Inspector's Report ACP-323742-25

Development	Proposed development comprising the development of an extension to existing St Brigid's Burial Ground.
Location	Drumcliff, Ennis, Co. Clare.
Local Authority	Clare County Council
Type of Application	Application for approval made under Section 177(AE) of the Planning and Development Act, 2000 (local authority development requiring appropriate assessment)
Prescribed Bodies	Development Applications Unit, DoHLGH Uisce Eireann
Observer	Dermot Anthony Queally Robert Behan Pat Tierney Michael Duffy
Date of Site Inspection	5 th February 2026
Inspector	Donogh O' Donoghue

PROJECT: Burial Ground Extension
ADDRESS: Drumcliff, Ennis, Co.Clare

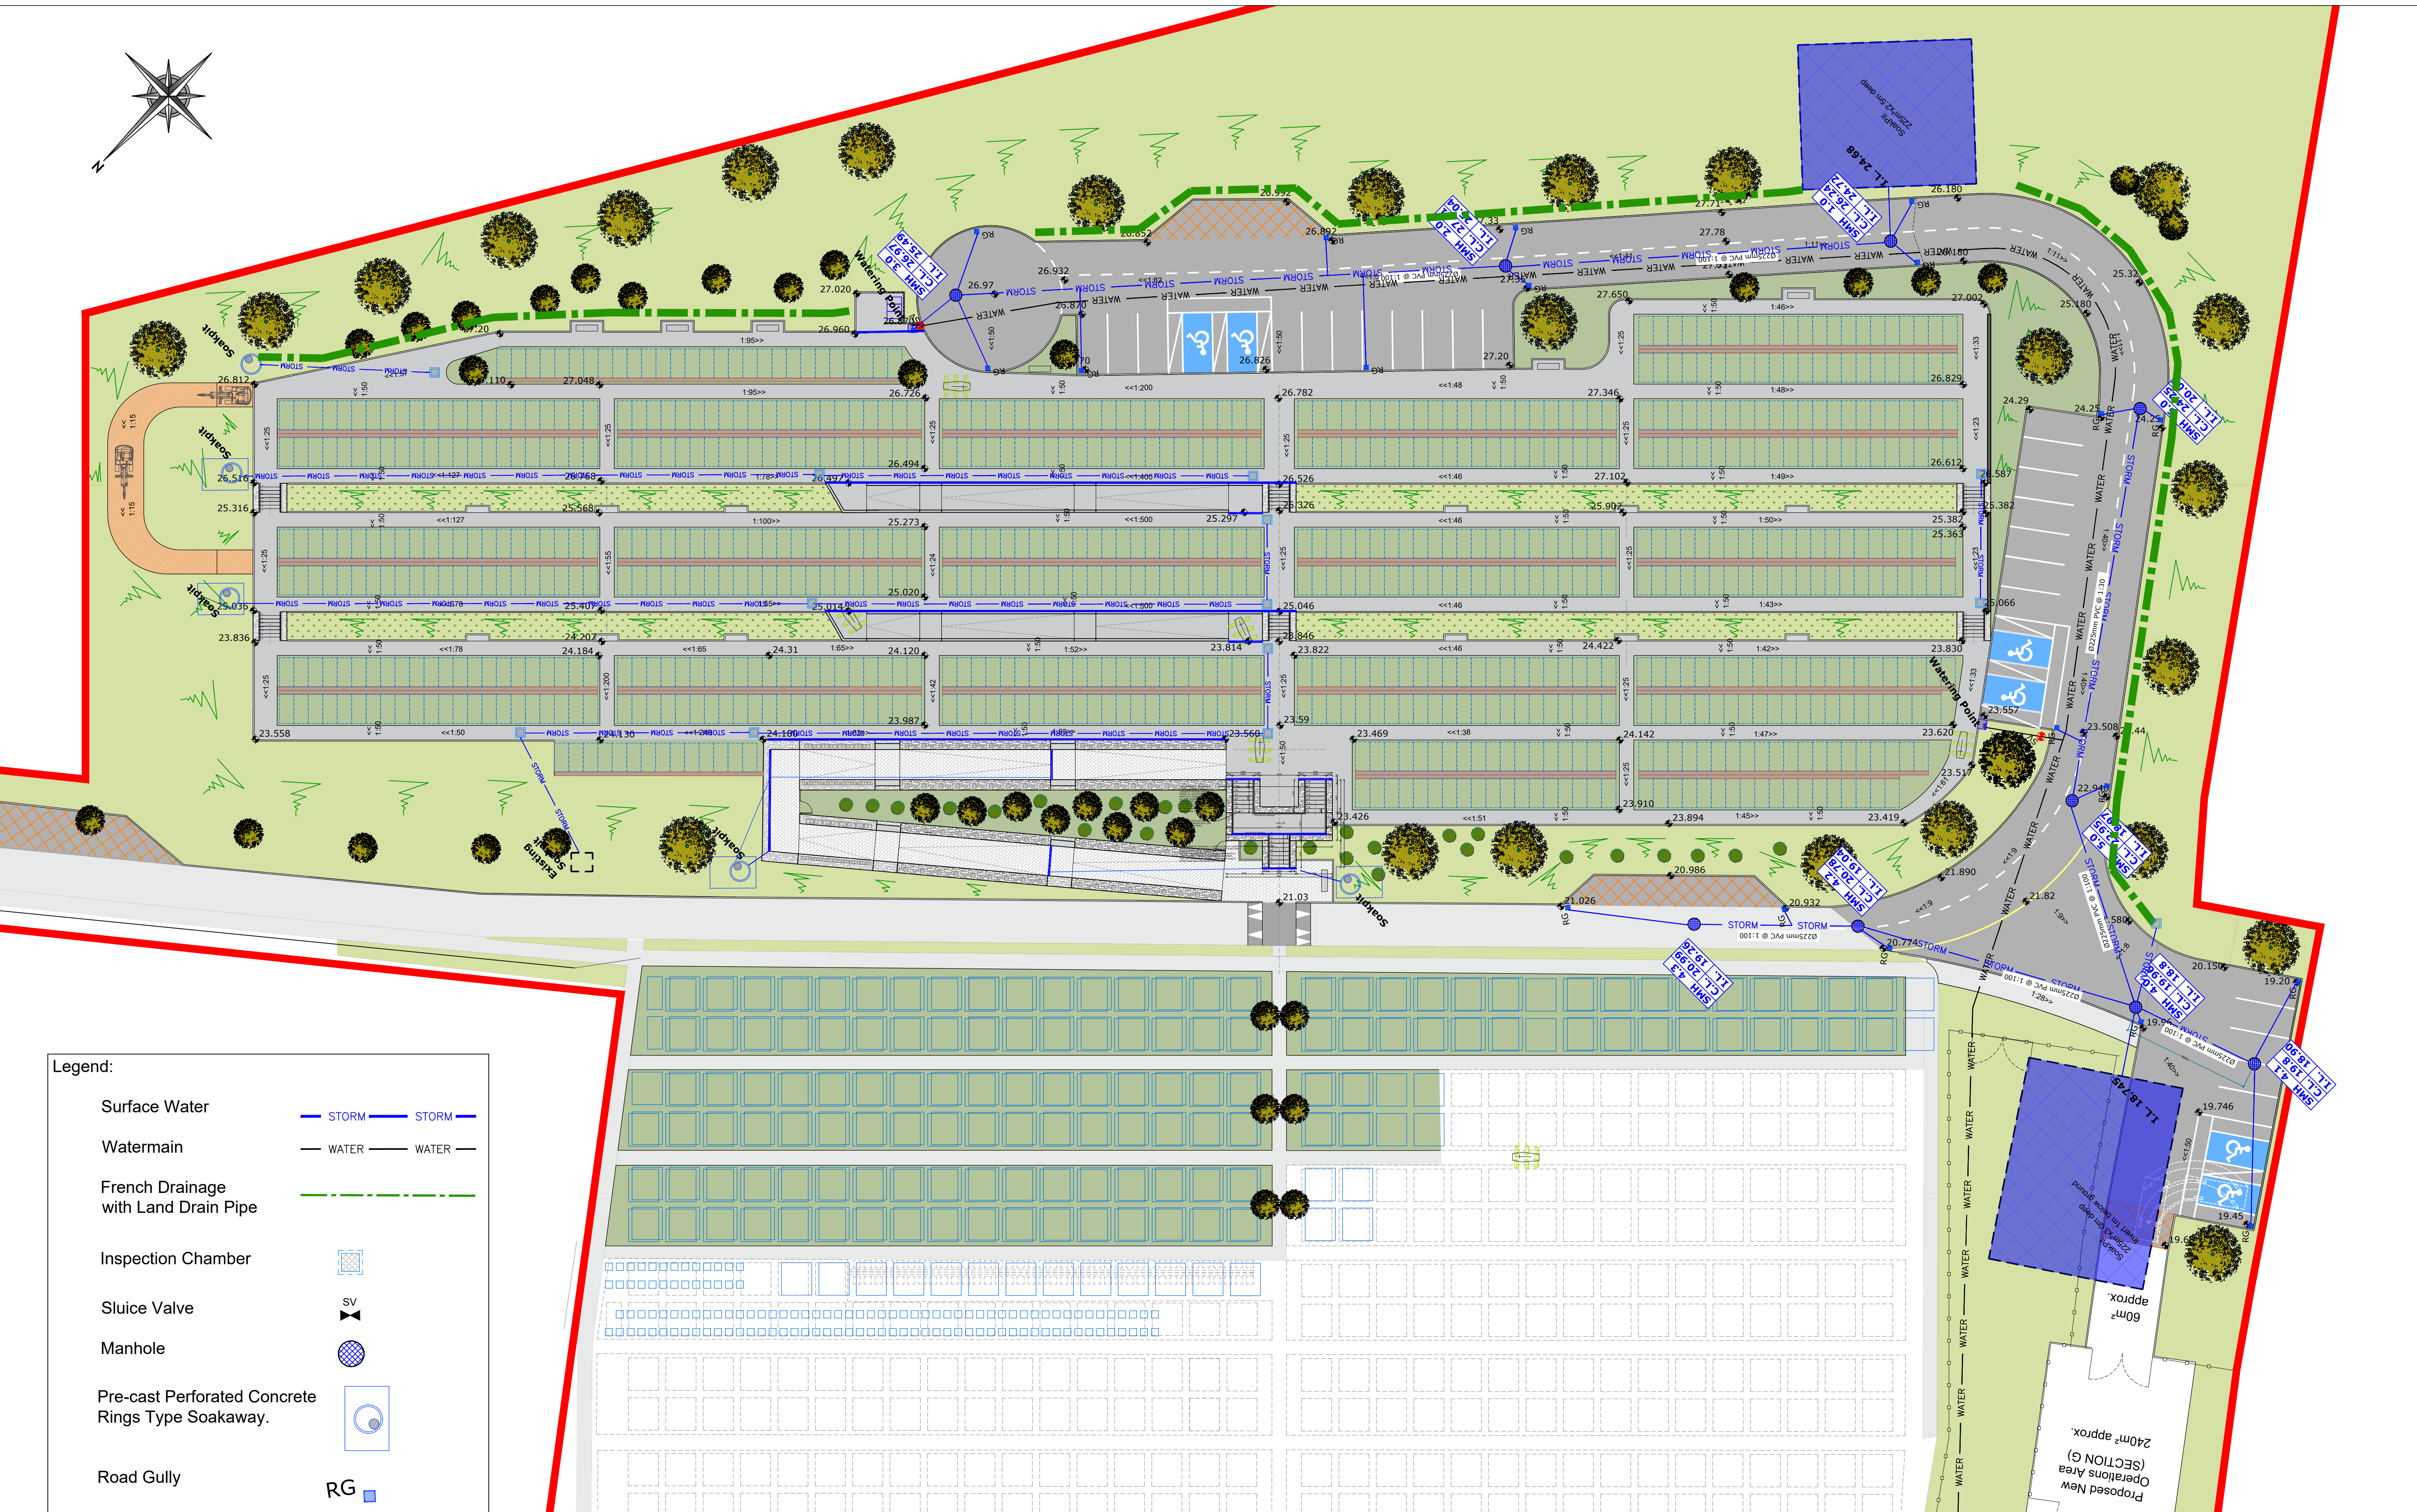
- All these problems can be directly traced back to the inability of existing stormwater drainage from graveyard being contained and dispersed of adequately within its own bounds. Indeed the current method uses existing drains which have not got the capacity to manage same.

- This leads to overflow of drains, flooding to public road and egress on to his lands around his septic tank. Naturally this should be of concern from a public health issue.

- He also notes that the application is proposing 2 No soakaways but has concerns that this is adequate and sufficient to prevent flooding to his property and public road and its associated public safety issues.

- All surface water generated on the proposed extension will be captured and fully infiltrated on-site via soakaways and direct infiltration into green areas. There will be no discharge from the site to the public road or any downstream lands.

- Surface water falling on green (grave) areas will infiltrate directly into those areas.
 - Footpaths are sloped toward adjacent green areas or collected via ACO drains and directed to dedicated soakaways.

- Roadway runoff is served by French drains with land-drain pipe leading to a dedicated soakaway at the lowest point of the drainage run.
 - Gullies at the existing/proposed roadway.

- The design of the 2 no. soakaway pits has been informed by trial pitting and associated 5 no. soakaway tests to BRE digest 365 standard, with the soakaways being sized to accommodate runoff from the proposed extension.
